**CITY OF PORTLAND, MAINE
DEVELOPMENT REVIEW APPLICATION
PLANNING DEPARTMENT PROCESSING FORM**

Single Family Home

13 - 13 Daggett St , Portland, Maine

Subject: Application ID: 2010-0010

FRONT ELEVATION

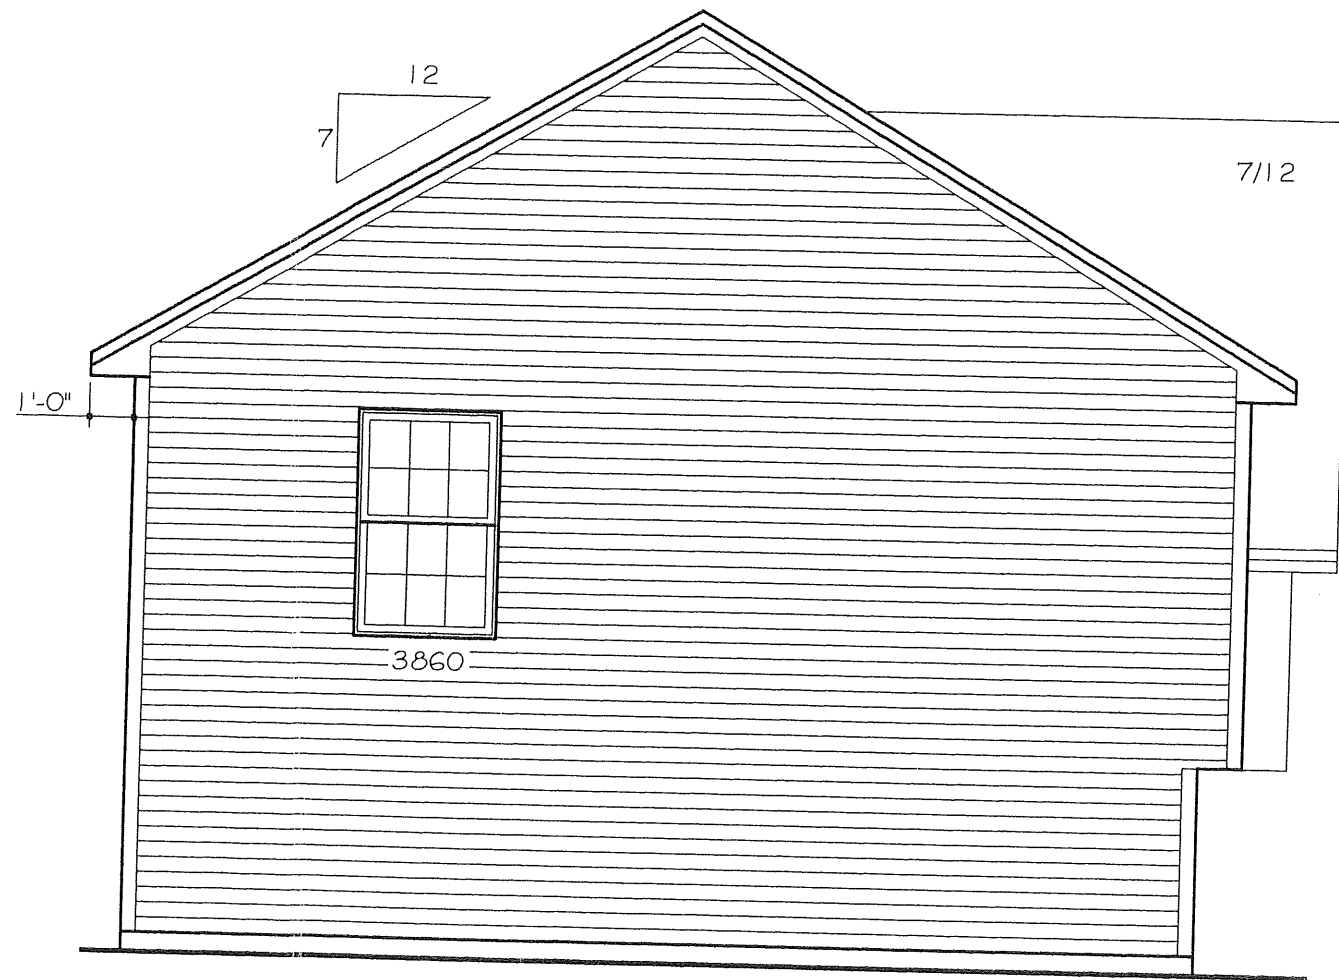
Field verify footina/ foundation drops dependent
